From: Judith Ward
Sent: 20 July 2020 15:33
To: Linda Griffiths
Subject: Allotment scheme 20/00814/OBL

The allotment scheme has not included the comments I made in April see below:

Judith Ward
Landscape Planning Officer
Cherwell District & South Northants Councils

Drawing Title
LANDSCAPE PROPOSALS (SHEET 14 OF 15)

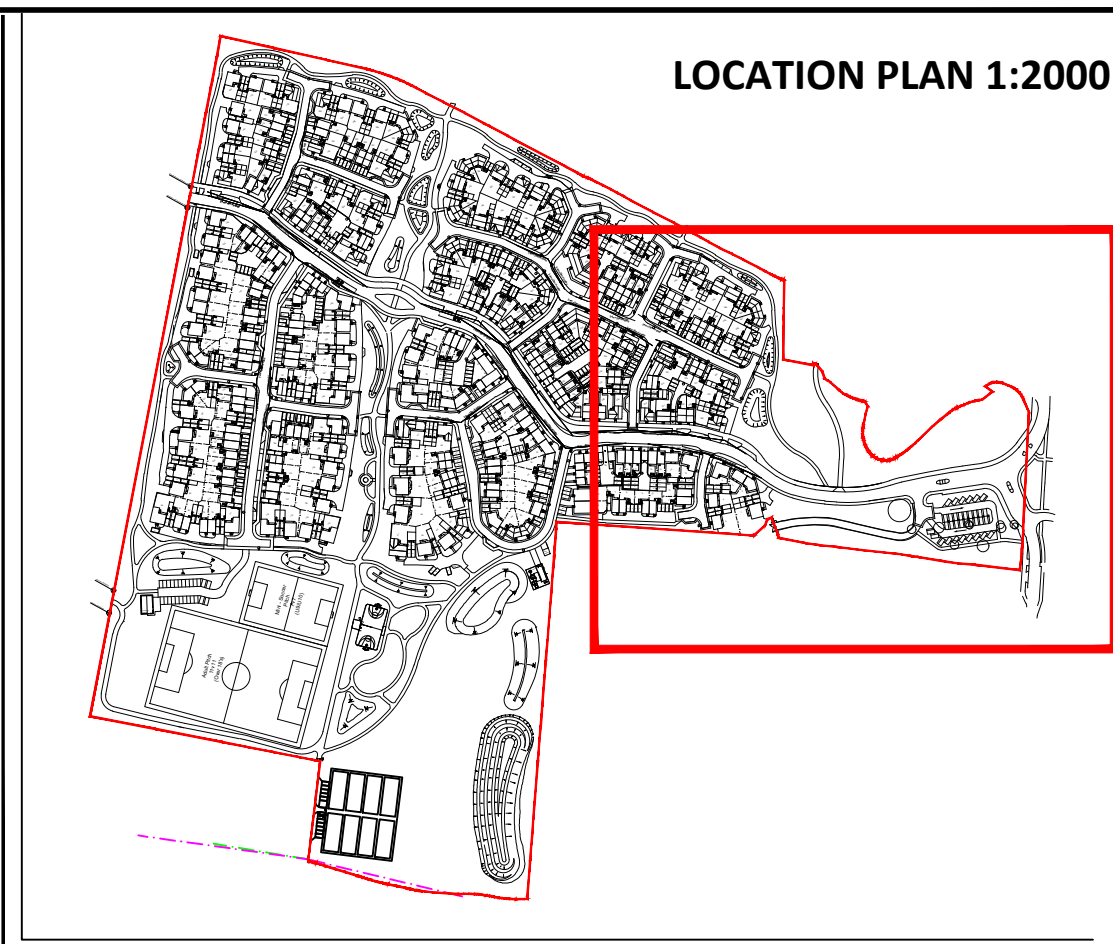
There is no right of access to these allotments as the track near them is in other ownership. This has not been thought out.

The access track from Wykham Lane is still open which isn't a good idea. I am not happy with a single file track from the development with no passing places and no speed limiters. More detail is needed. What is the surface. How will they stop boy racers?

The route to the access gate is over grass this is hopelessly inadequate for transporting materials over.

Plot sizes need indicating. These look very large. I can't measure from a laptop. They need to show dimensions

Parking bays need to be tarmacked. Justification for number of bays to plots?

There needs to be a concrete hardstanding for green waste to be deposited on and for waste bins to be stored. This can also be used for dropping off materials. Mike Hall at Banbury Town Council can provide a specification mike.hall@banbury.gov.uk. This needs to be inside the fenced area with vehicular access

A noticeboard with lockable doors is needed to provide information to plot holders

The site needs to be fenced with weldmesh fencing **at least 1.8m high with vehicular and pedestrian gates.**

All plots and their areas in m² should be indicated. A full plot is 250m², a half plot 125m².
Paths to be 1.4m wide crushed stone. **A 3m wide haulage way through the centre**

Cycle stands are needed

Topsoil on plots to be 450mm deep to BS 3882 2007 and cultivated to fine tilth. Free of all pernicious weeds.

Lockable water stand pipes are needed so that hoses can be attached. Troughs are not adequate. All plots need access to a standpipe within 25m. One standpipe is not enough

While a native hedge around the periphery is a good idea a woodland isn't as it will cast too much shade with Oak and Maple trees. The hedge mix should omit Field Maple and Clematis vitalba which will smother everything and kill it.
